Subject: FW: P/15/22/DOC - land rear of Sefter School House, Sefter Road, Pagham

From: Kate Giddings <kate.giddings@arun.gov.uk>
Sent: 25 February 2022 11:42
To: Simon Davis <Simon.Davis@arun.gov.uk>
Cc: Planning.Responses <Planning.Responses@arun.gov.uk>
Subject: P/15/22/DOC - land rear of Sefter School House, Sefter Road, Pagham

Condition 14 (Construction Management Plan)

Dwg Ref : CMP-01A

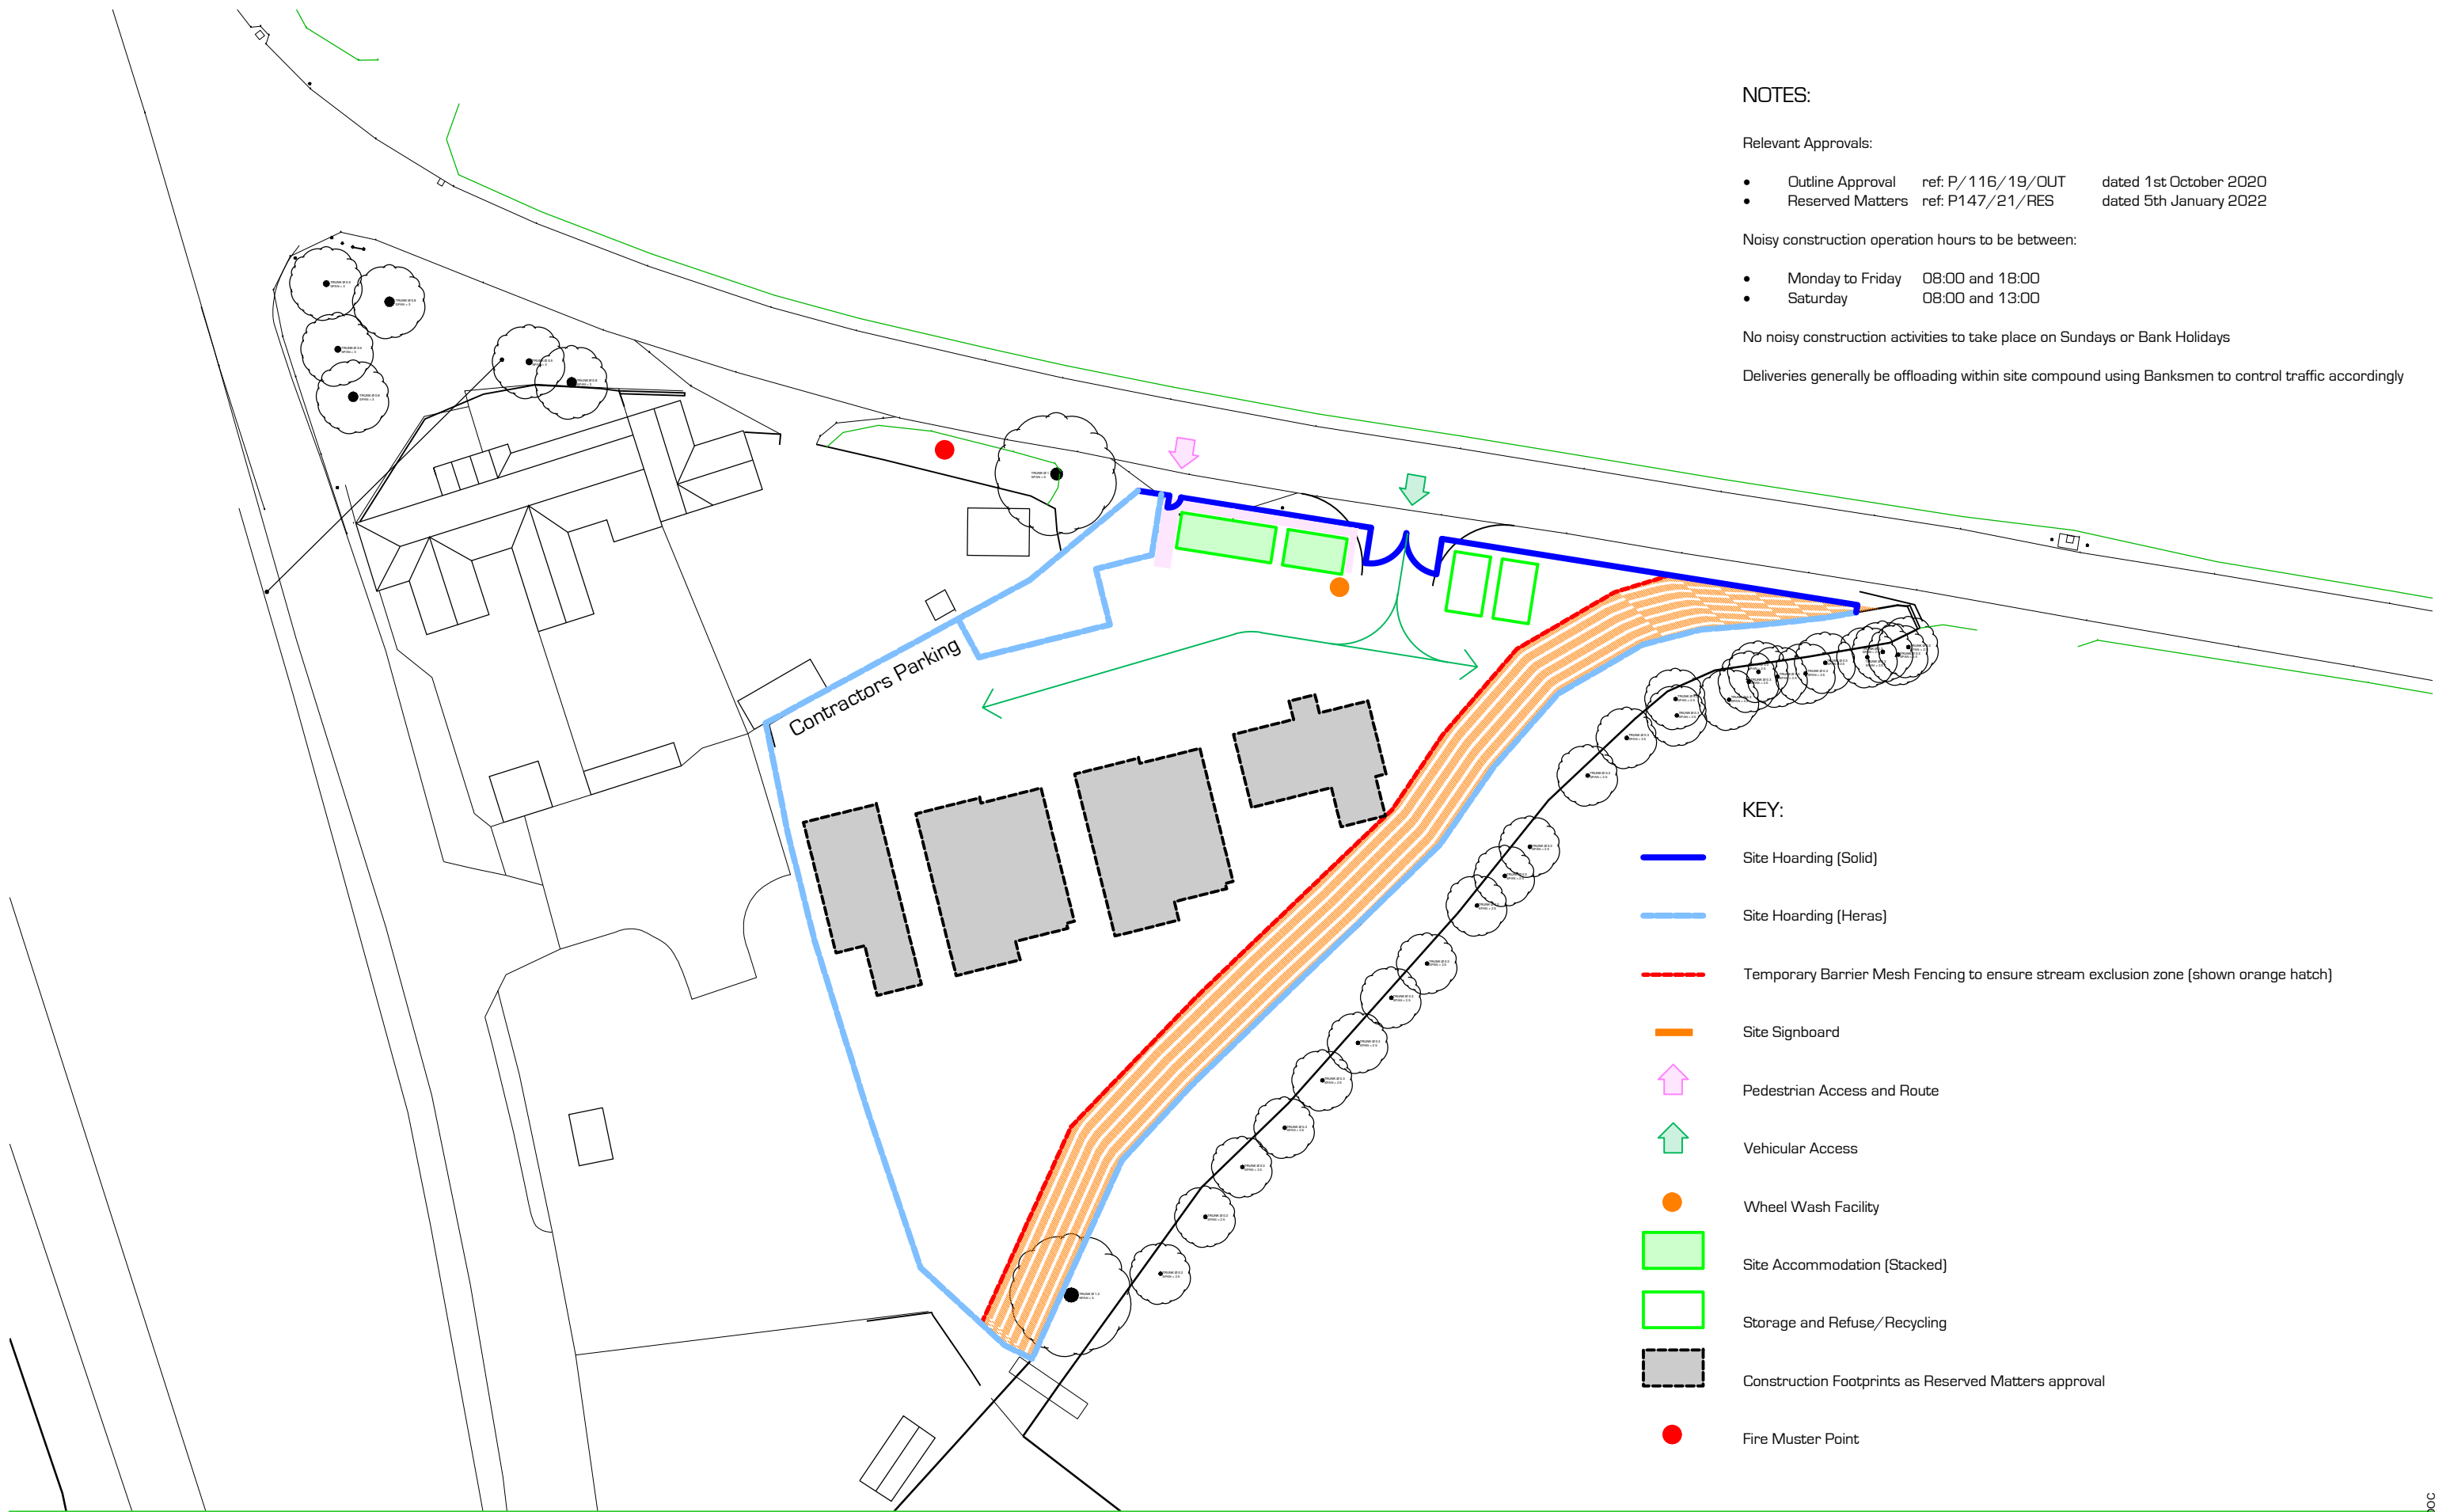
The submission provided (Dwg no. CMP-01A, dated January 2022) does not suitably address the requirements as outlined in the condition, therefore this Department cannot recommend discharge. The CMP submission is helpful but it doesn't provide any specifics relating to items listed within the condition. It is appreciated that the list is not exclusive but more detail is required.
